**Town of Addison
Summary of Engineering Revision Comments**

Development: Galaxy FBO

Town Project #:19-09D

C10.06

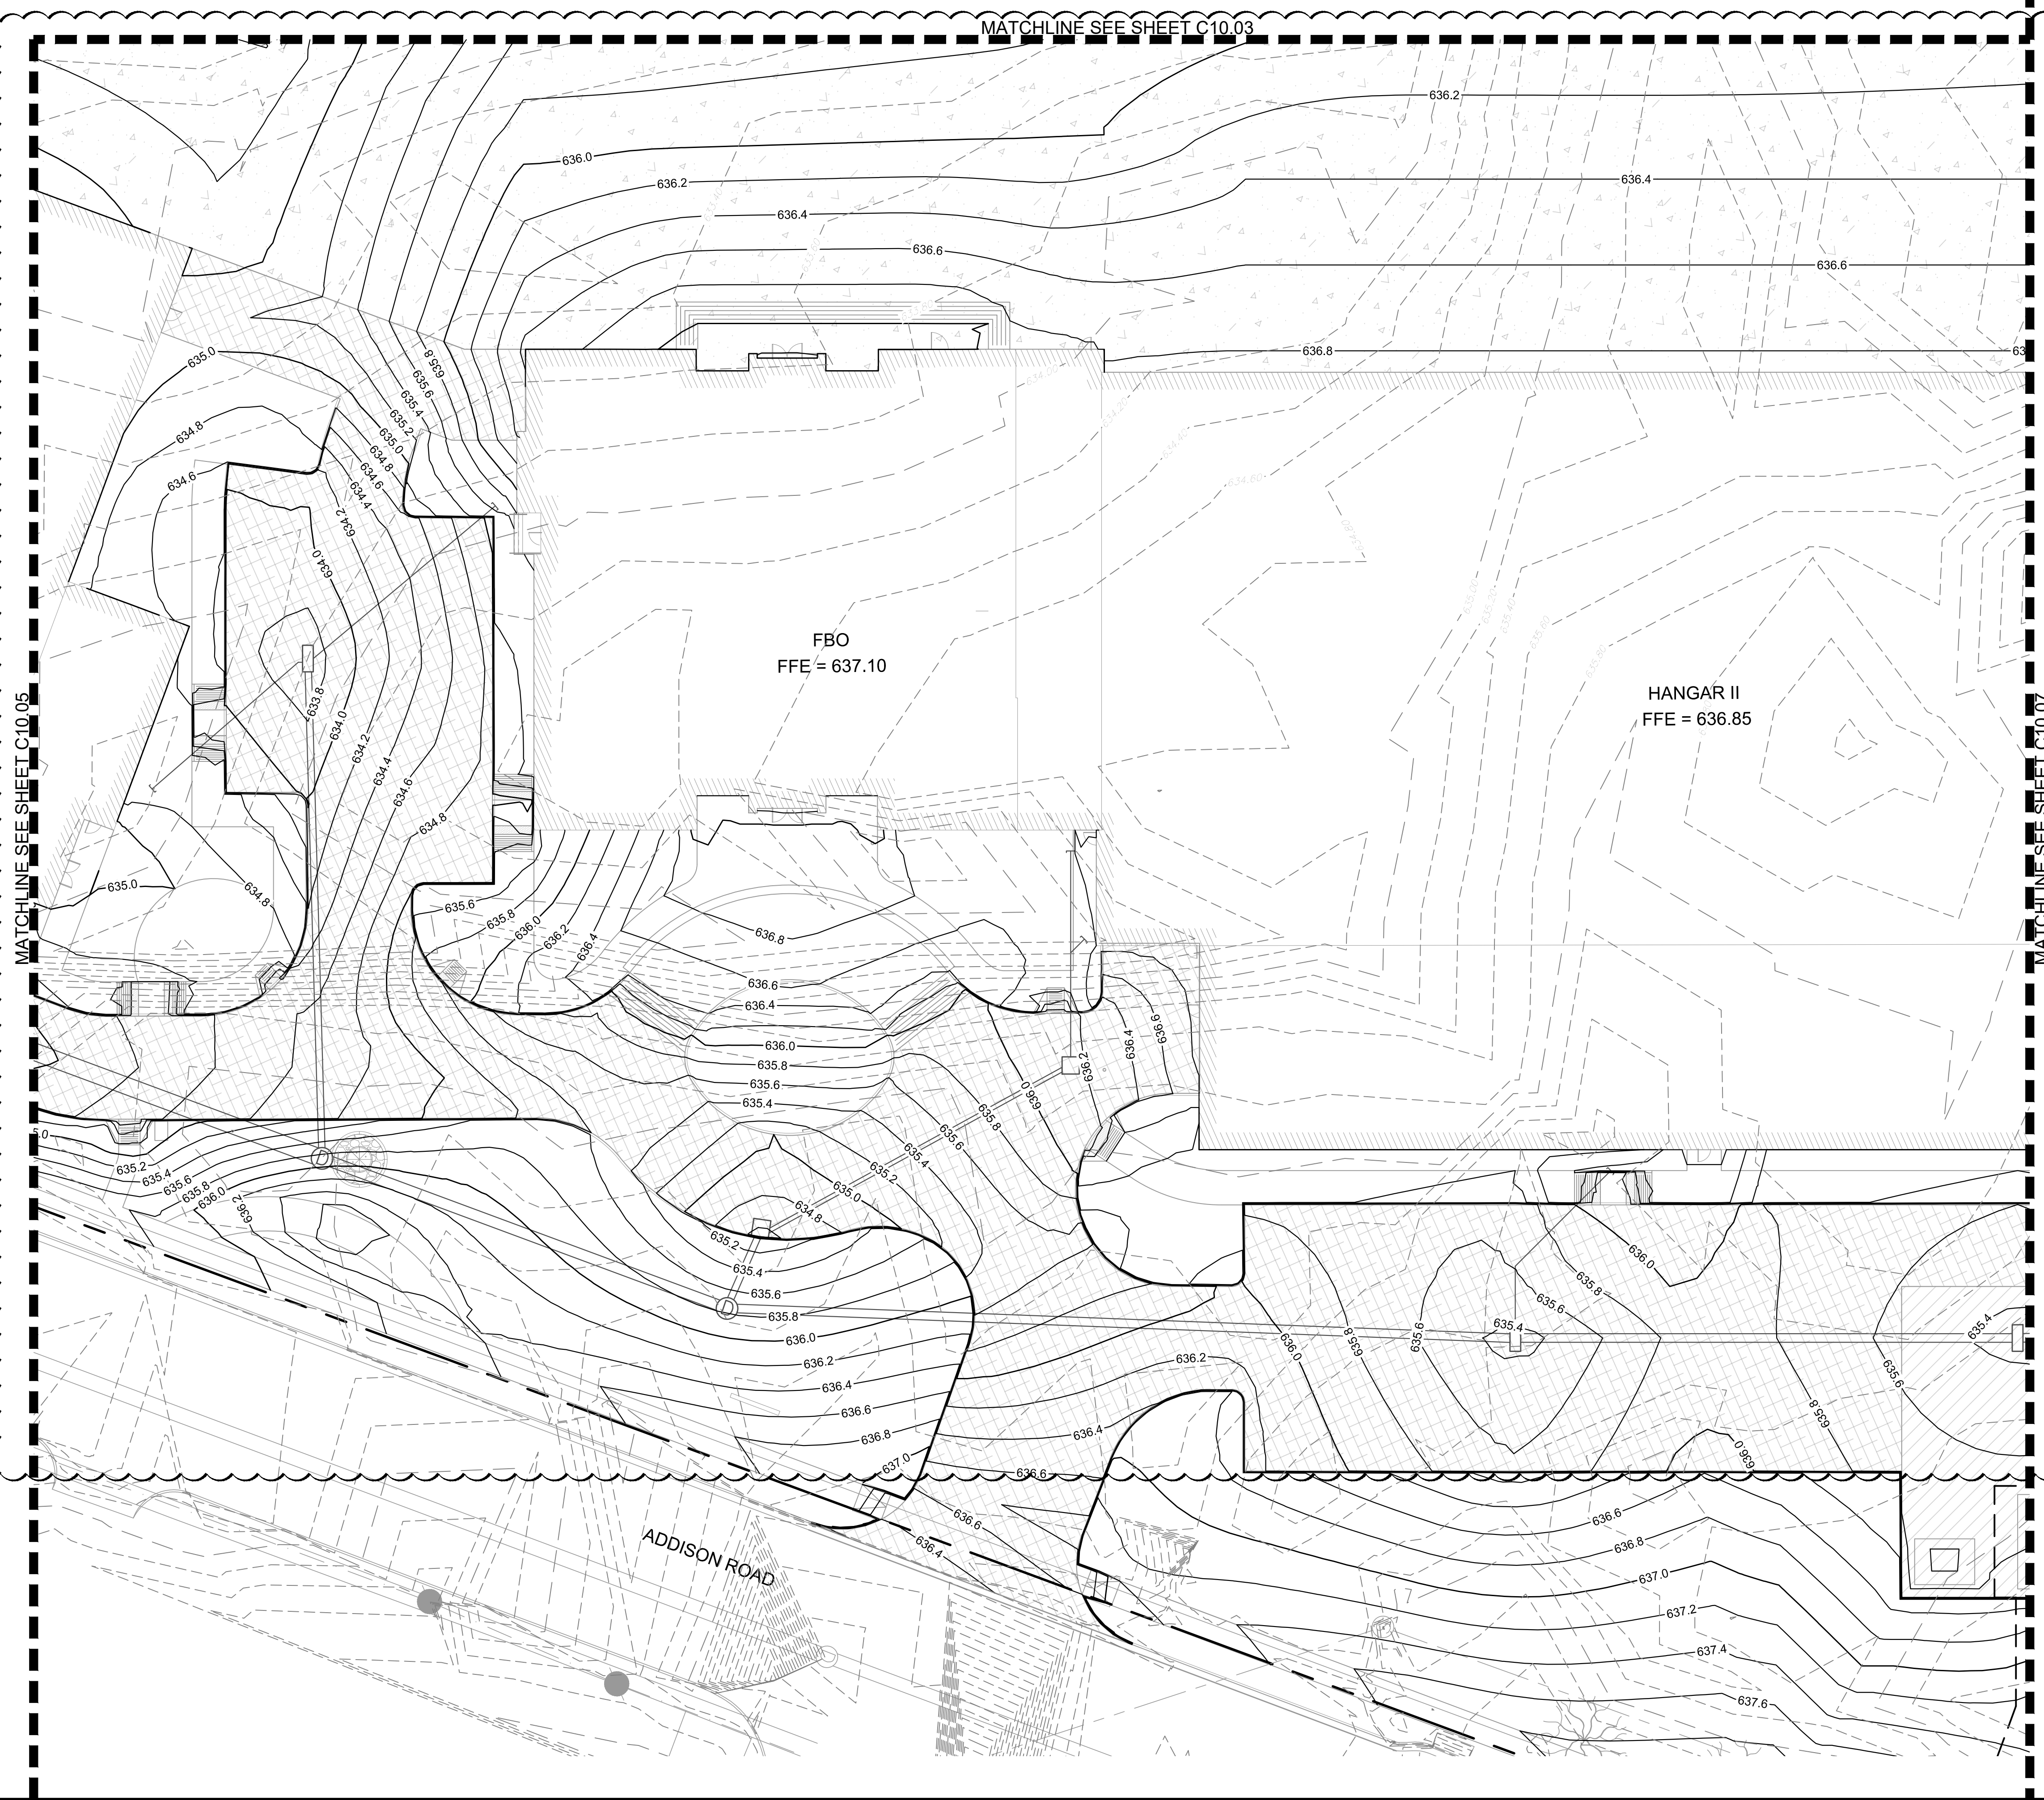
ASI-C006	10/30/2020	C10.04	Updated grading per field conditions verified by a construction progress topographic survey.	
ASI-C006	10/30/2020	C10.05	Updated grading per field conditions verified by a construction progress topographic survey.	
ASI-C006	10/30/2020	C10.06	Updated grading per field conditions verified by a construction progress topographic survey.	
ASI-C006	10/30/2020	C10.07	Updated grading per field conditions verified by a construction progress topographic survey.	
ASI-C006	10/30/2020	C10.08	Updated grading per field conditions verified by a construction progress topographic survey.	
ASI-C006	10/30/2020	C12.02	Updated rim and top of grate elevations on storm structures per field conditions verified by a construction progress topographic survey.	
ASI-C006	10/30/2020	C12.03	Updated rim and top of grate elevations on storm structures per field conditions verified by a construction progress topographic survey.
